Office of
Environment
& Heritage

Our Ref: DOC18/230897

Re: Altitude Aspire Residential Subdivision (MP 09_0166 MOD 3), Terranora Tweed LGA

Attachment 1: Detailed OEH Comments – Altitude Aspire Residential Subdivision (MP 09_0166 MOD 3)

NEWLAND DEVELOPERS PTY LTD	09-374 16-11-2017
TERRANORA PRECINCT 1 WEST BOUNDARY EARTHWORKS EXTENT	SK 6524 REVISION A

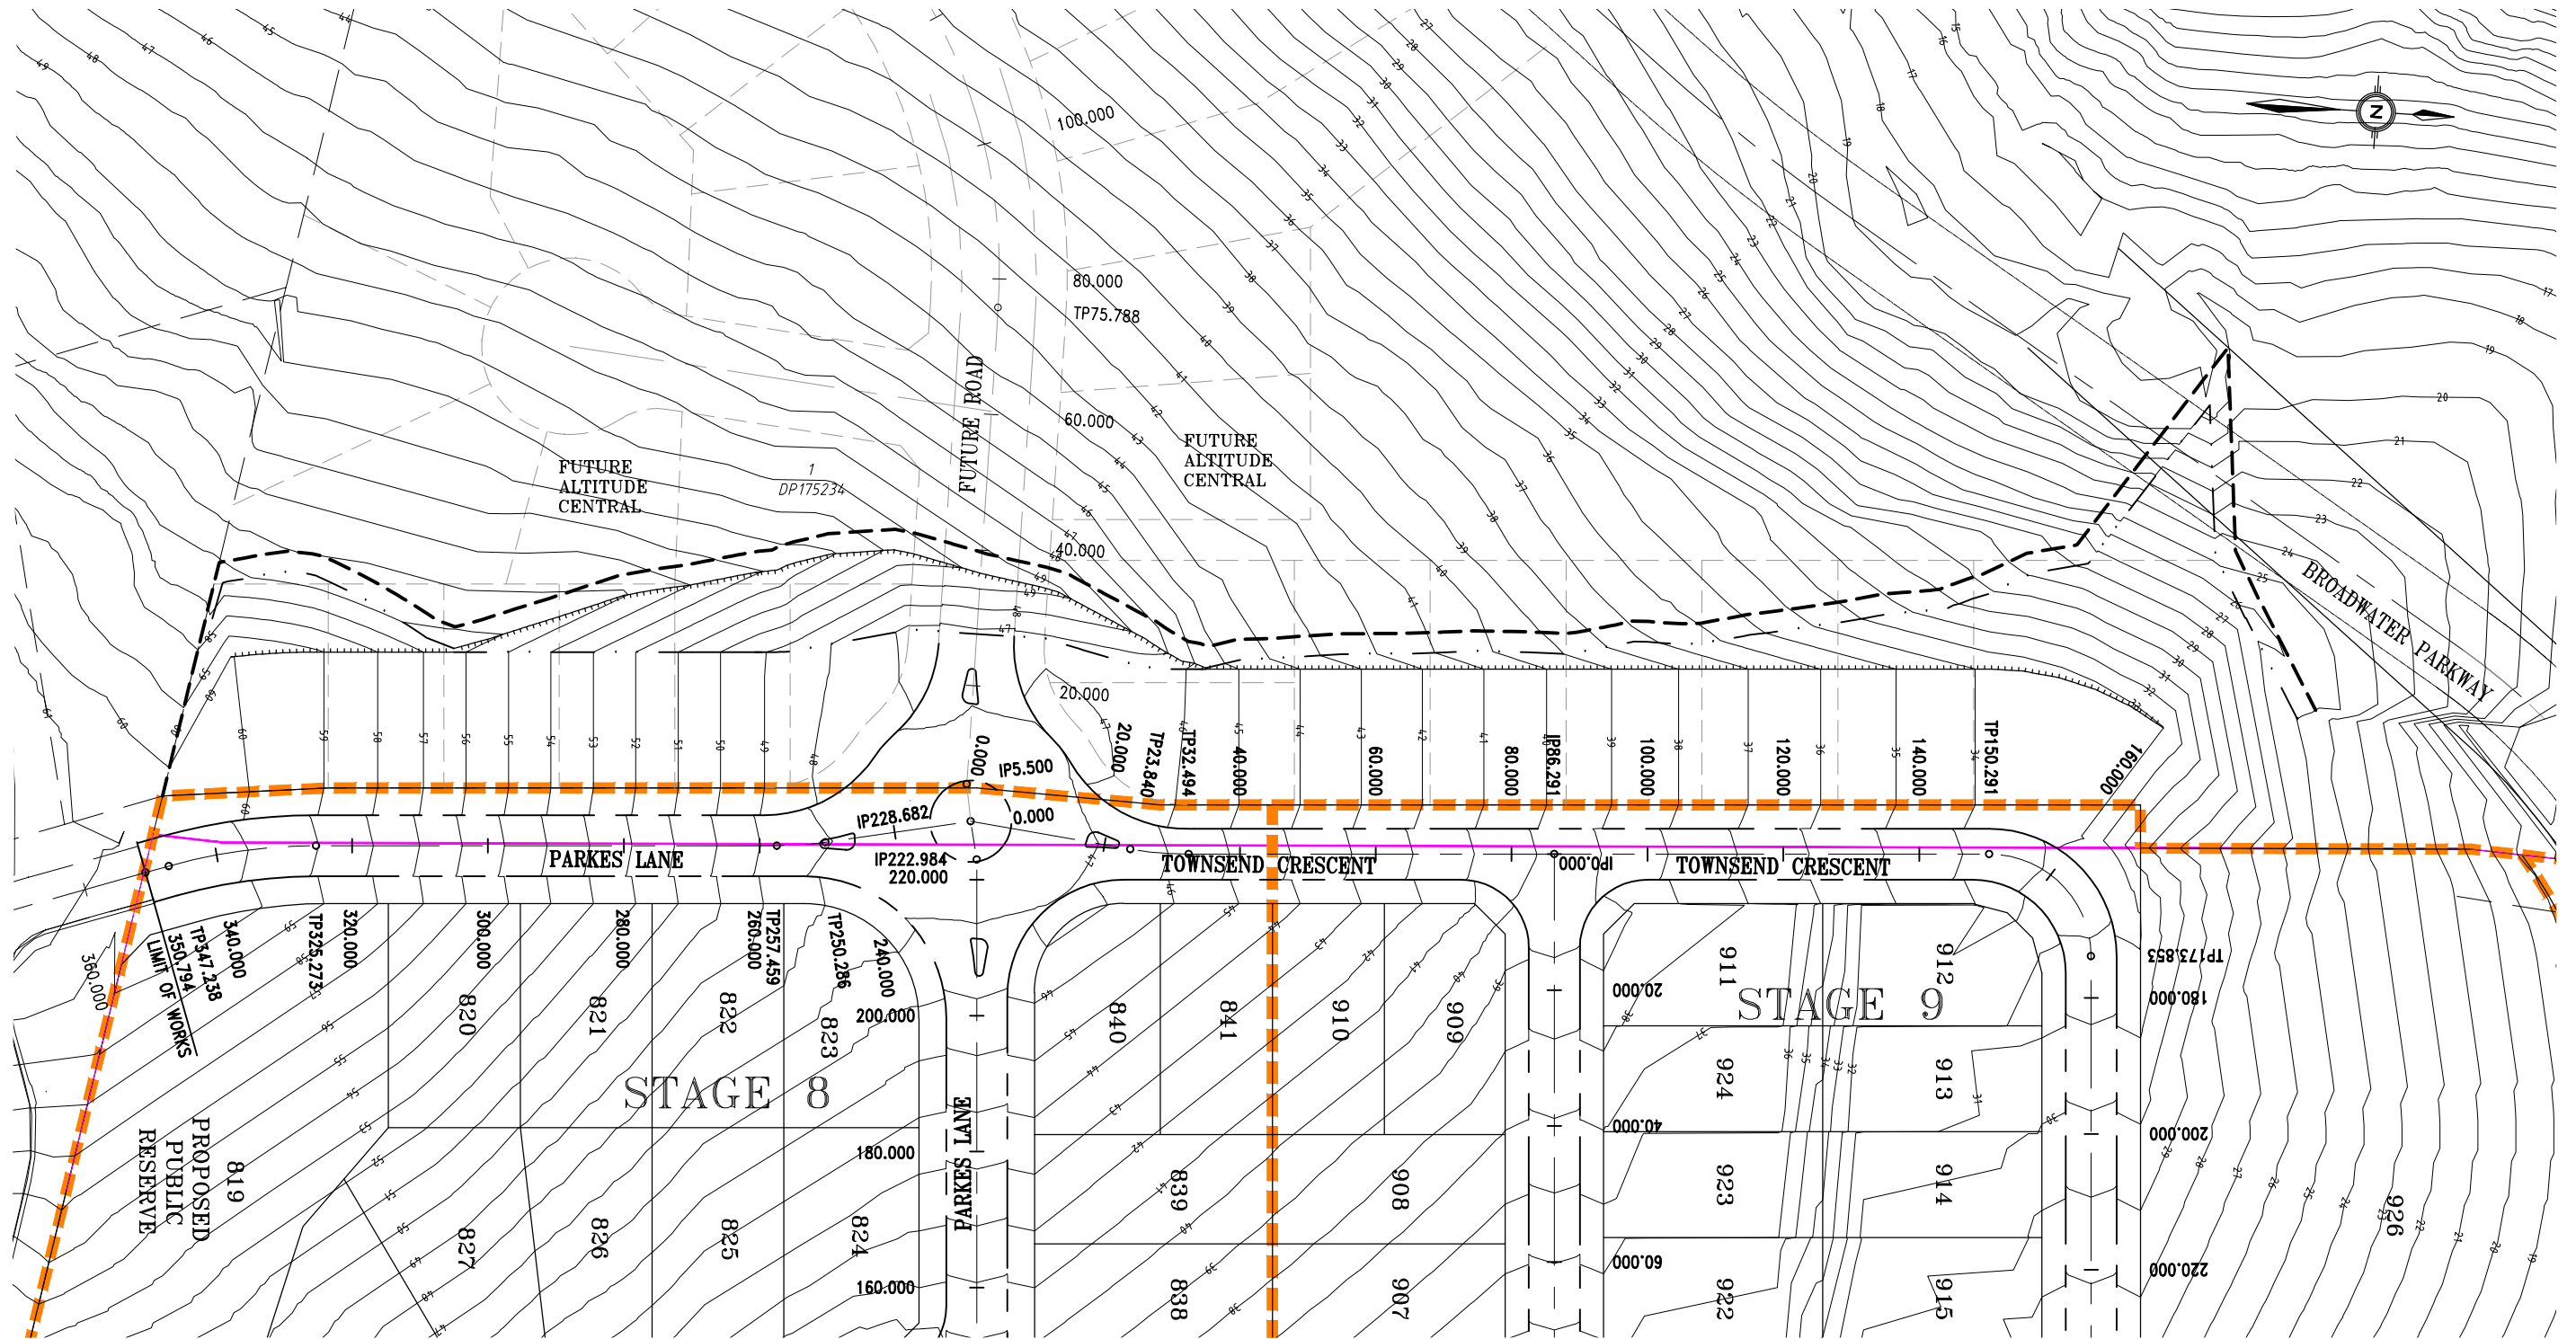
The bulk earthworks are proposed to extend onto the adjoining property Lot 1 DP 175234 No. 93 Parkes Lane. There is no development application or existing approval for subdivision or bulk earthworks for Lot 1 DP 175234 on the Tweed Shire Council's DA tracker. It is not clear how approval for this component of the works can be given as this area was not part of the original Part 3A consent.

The ecological assessment by Burchills also maps the vegetation on Lot 1 DP 175234 in the area to be impacted by the bulk earthworks as Type A Tall Closed Forest (*Cinnamomum camphora*). The community is described as being dominated by camphor laurel as a canopy species with a mixed mid-storey of rainforest regrowth and exotic weeds.

There is no assessment of the proposal's impacts on this EEC under the FBA. The OEH therefore considers the impacts on this EEC have not been adequately assessed. Impacts on both *Macadamia tetraphylla* and the EEC should also be considered under the Commonwealth *Environment Protection and Biodiversity Conservation Act 1999* (EPBC Act) and may require a separate approval, noting the *Lowland Rainforest of Subtropical Australia* is a critically endangered ecological community under the EPBC Act.

1. The Department of Planning and Environment considers the validity of assessing the proposed works as a Part 3A modification, given the proposal involves works on an adjoining land parcel that was not subject to the original approval.

2. The ecological assessment be updated to accord with the Framework for Biodiversity Assessment for impacts to biodiversity arising from the modification, including the Lowland Rainforest endangered ecological community and the threatened flora species rough-shelled bushnut (*Macadamia tetraphylla*), which have been recorded in the area subject to the modification.
